# COUNTY COUNCIL'S RESPONSE TO CONSULTATION ON THE FOLLOWING DEVELOPMENT PROPOSAL

**Application no:** 24/02514/OUT

**Proposal:** Outline planning application for up to 114 dwellings and associated open space with all matters reserved other than access - re-submission of 23/03366/OUT

**Location:** Land Opposite Hanwell Fields Recreation Adj To, Dukes Meadow Drive, Banbury

Client: Manor Oak Homes		Project: Hanwell Fields, Banbury	
Title: Existing and Proposed Roundabout Geometry Plan Junctions 9 Input Data	Date: 24/09/21 Drw: AN Chk: DB		
Drawing No: 340-TA120		Revision:	Scale: 1:500 Size: A3

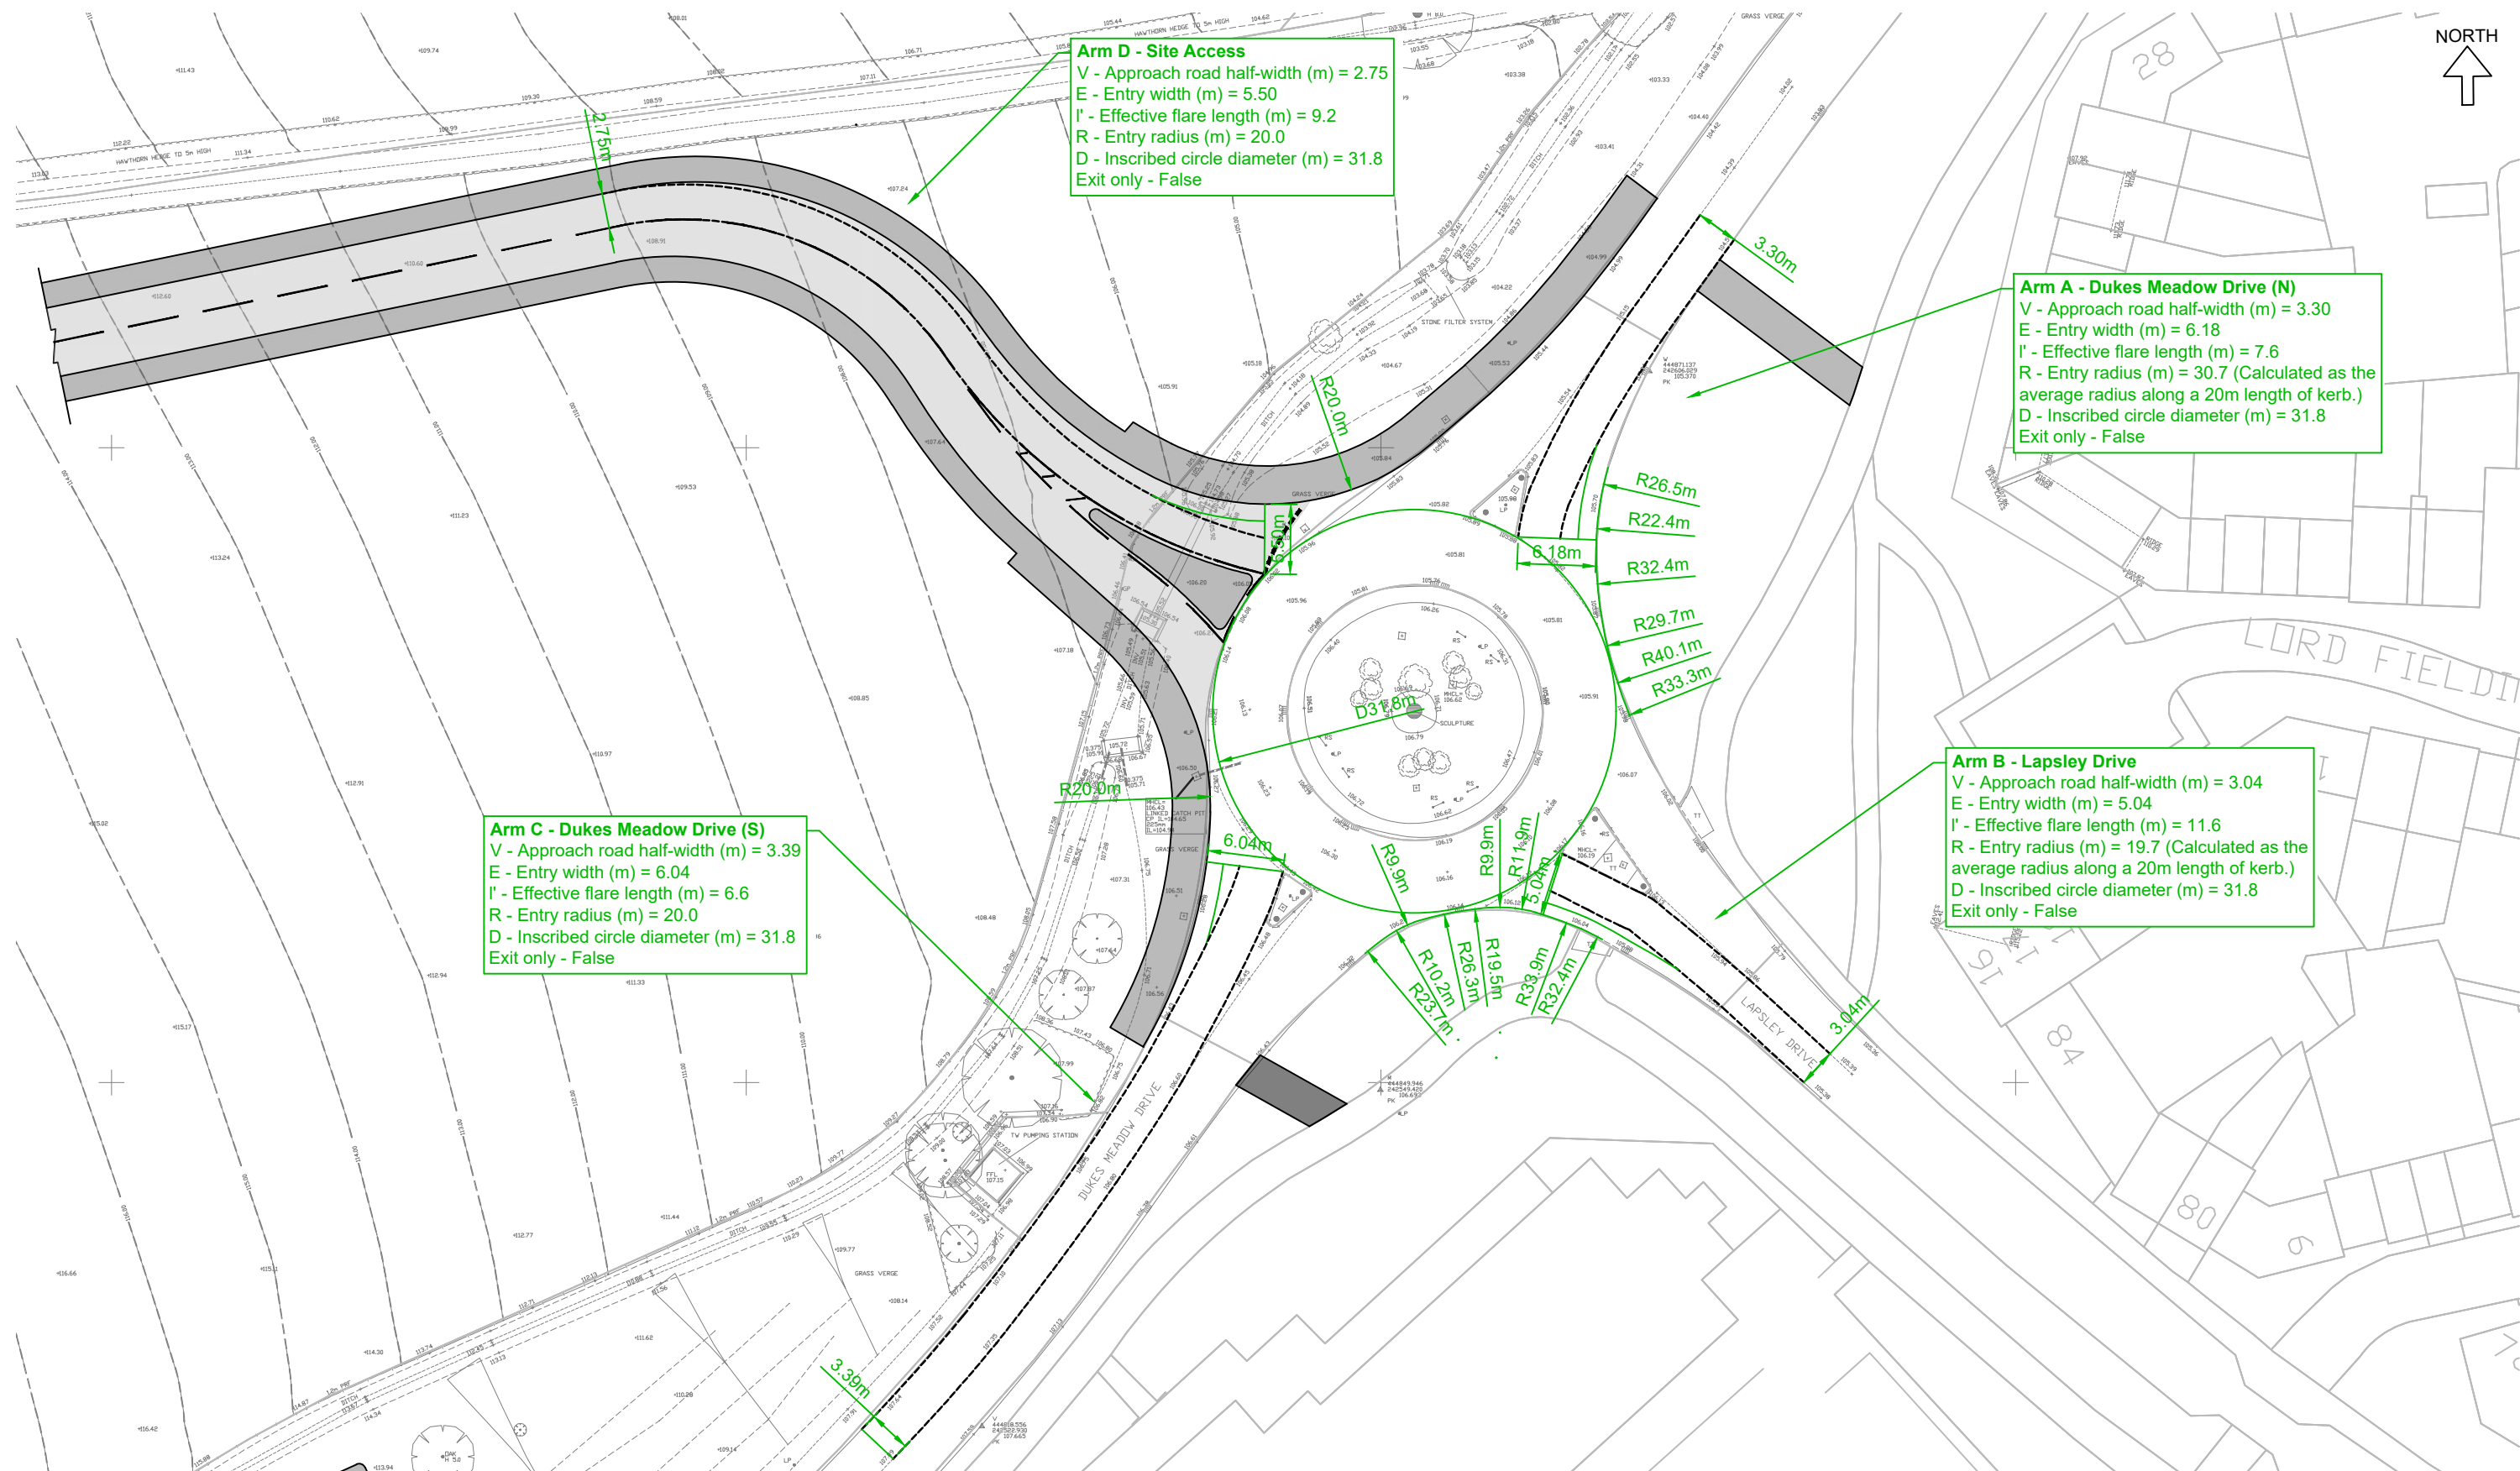
The proposed development will be accessed via a fourth arm (western arm) of the existing Dukes Meadow Drive/ Lapsley Drive roundabout. MAC Drawing no: 802-TA10 Rev B shows the 5.5m wide continuation/ realignment of the consented Phase 1 development access off the Dukes Meadow Drive roundabout. Allied to this will be a 3m wide shared footway/cycleway on either side of the carriageway

- Is the new roundabout arm serving these developments designed to a Compact or a Normal Roundabout? This will be helpful to know which design criteria we need to review against within CD 116 Geometric design of roundabouts. We have made general comments which cover both roundabout designs.
- Please amend the entry and exit width for the site access in accordance with point 3.6 of CD 116 - *The width of the circulatory carriageway for normal or compact roundabouts shall be between 1.0 and 1.2 times the maximum entry width, excluding*

any overrun area. As shown below the circulatory carriageway width is 6m, so the minimum entry width will need to be 6m. Please amend to the entry width from 5.5m to 6m.

- If the site access is required to have a long traffic island, please can it be designed in accordance with Figure 3.28 in CD 116 as shown below. You can see from the below extract it does not meet the requirements. OCC is happy for the traffic island to be reduced to a similar length as the existing ones, but please ensure the minimum road width is 6m as highlighted below. At a compact roundabout, the exit width should be similar to the entry width.

- There needs to be a crossing facility around the traffic island to enable safe and suitable access from one side of the carriageway to the other across the access arm of the roundabout.

- Please provide entry path radius and deflection for the site access, Dukes Meadow Drive and Lapsley Drive. In accordance with Figures 3.20, 3.22 and 3.23 in CD 116. Please ensure the deflection does not exceed 100m for a normal roundabout and 70m for a compact in accordance with 3.24 - *At compact roundabouts in urban areas, where the speed limit is 40mph or less within 100 metres of the give way line on any approach, the entry path radius shall not exceed 70 metres.*

MAC drawing no. 802-TA14A

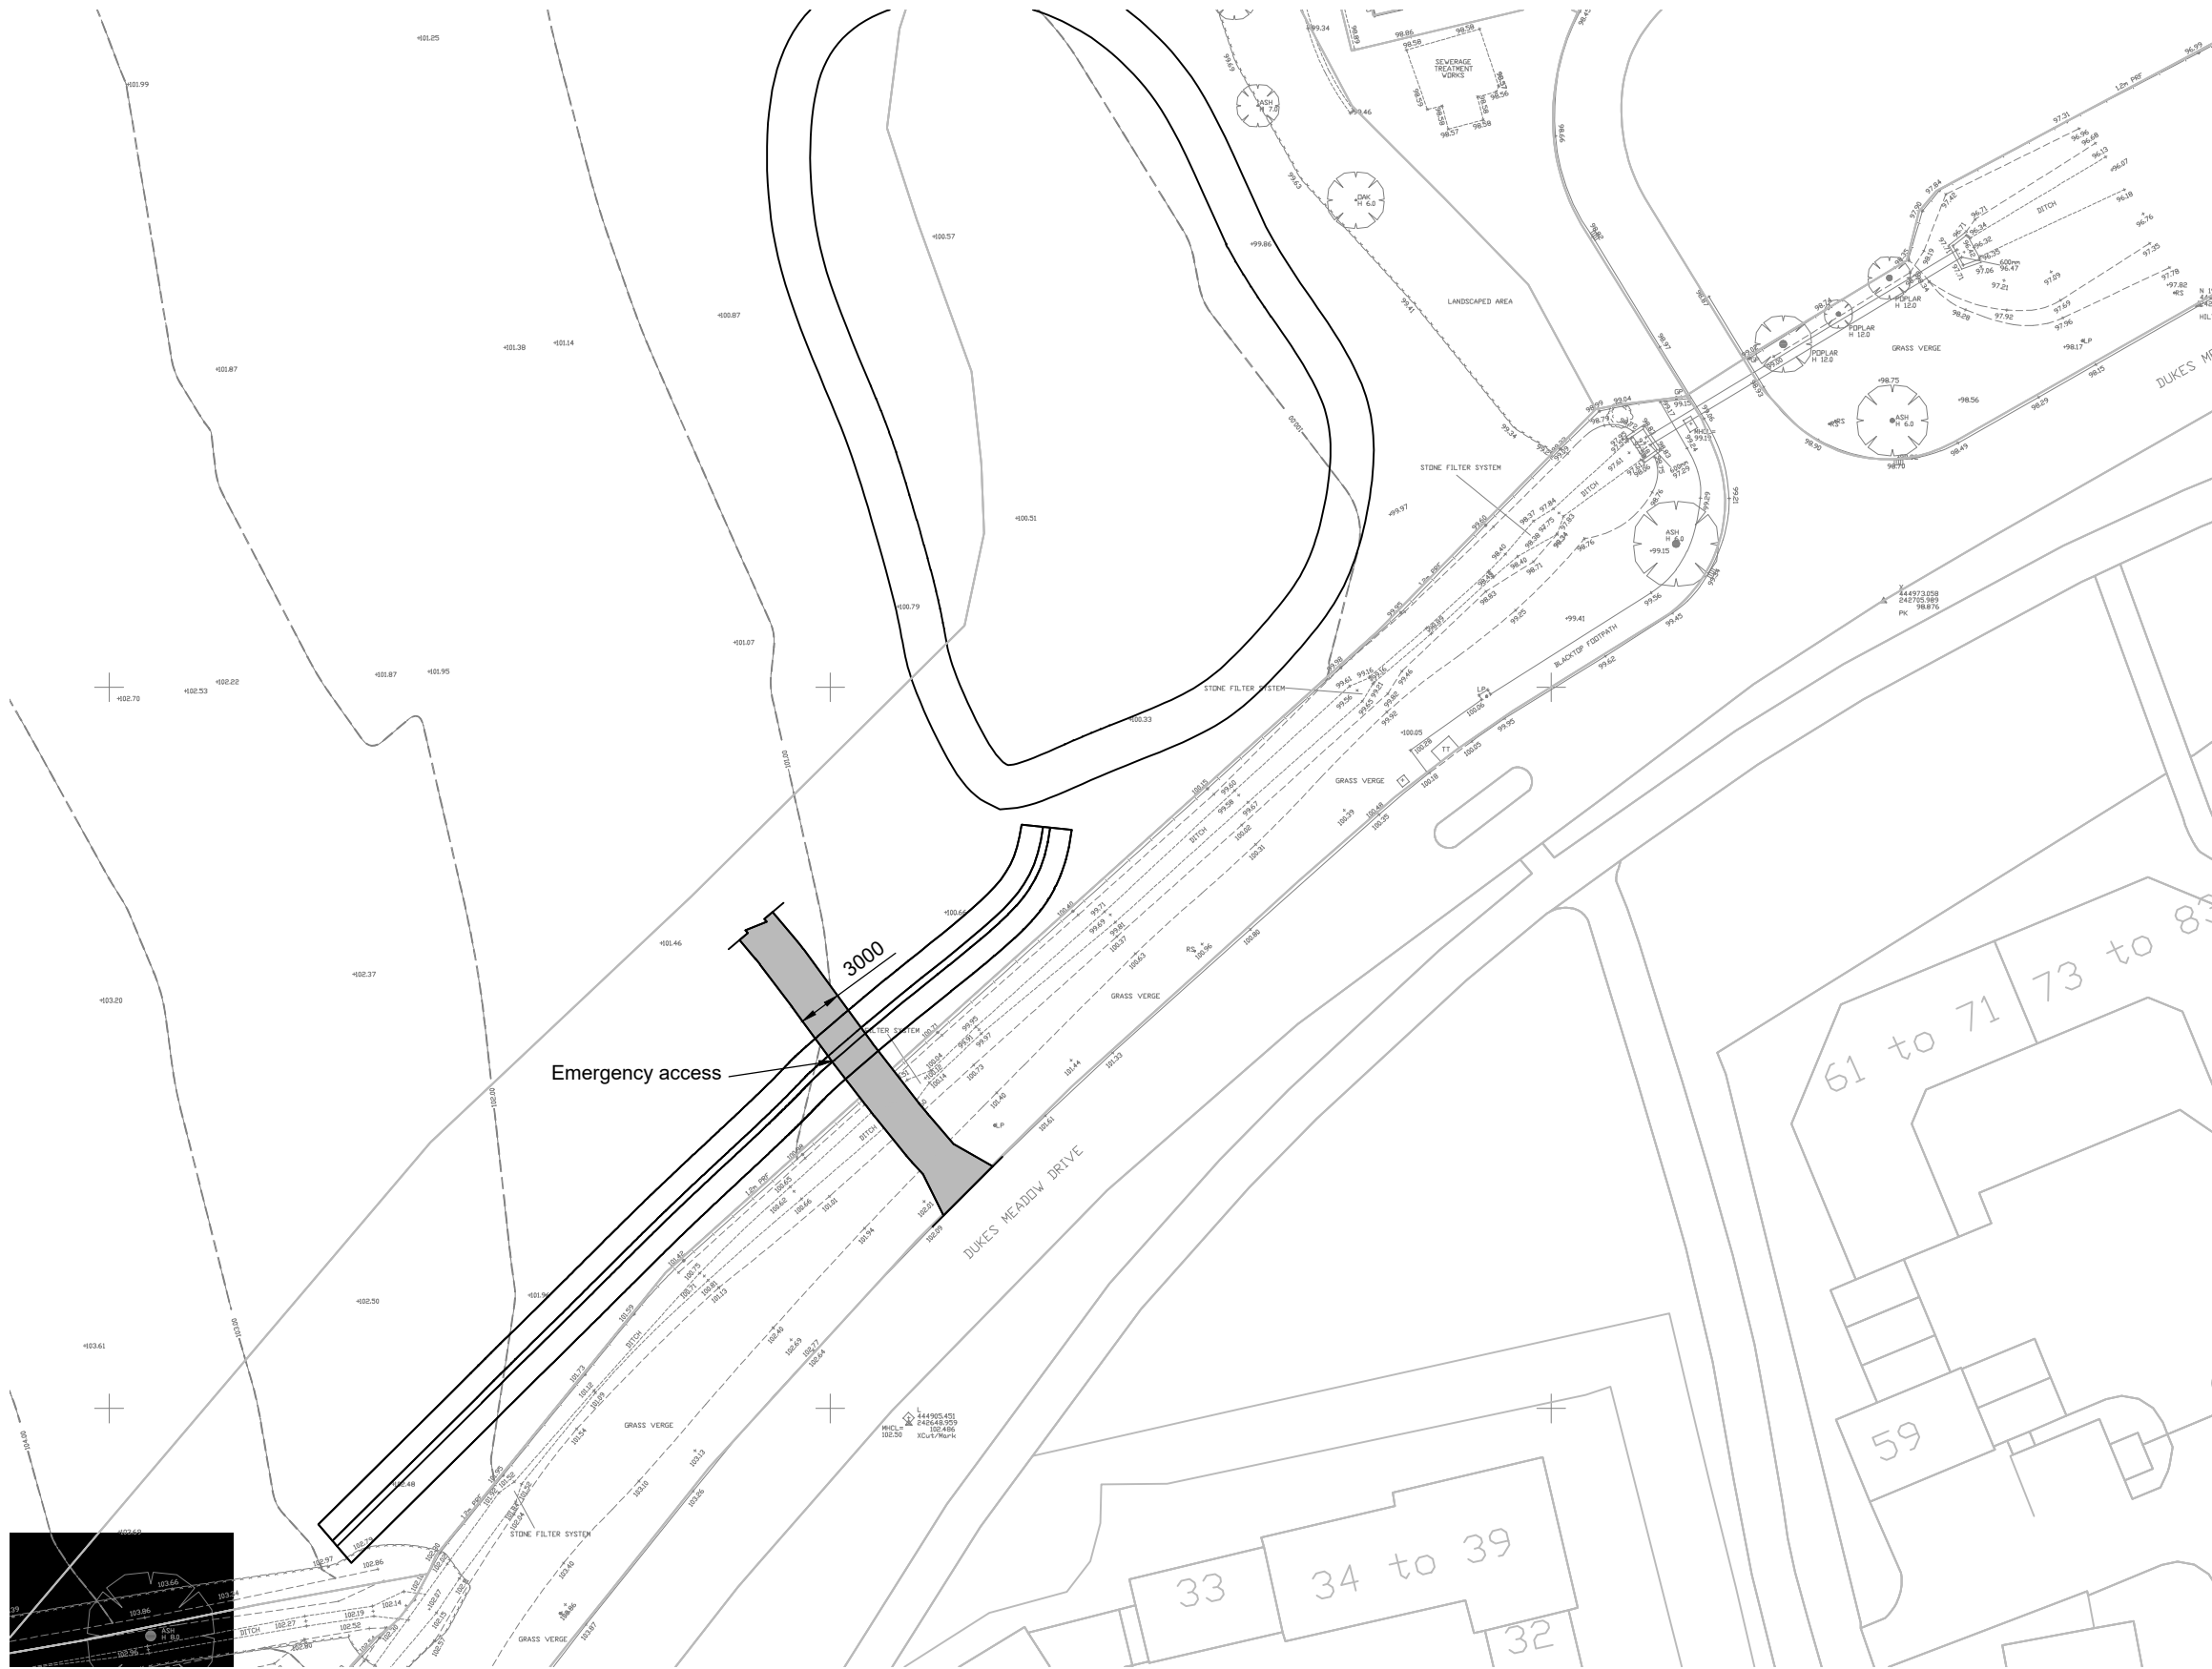
An emergency access is noted and welcomed. The application proposes to incorporate it off Dukes Meadow Drive to the south of the site as illustratively shown on MAC Drawing no: 802-TA14 Rev A which would at the same time serve as a shared pedestrian and cyclist access.
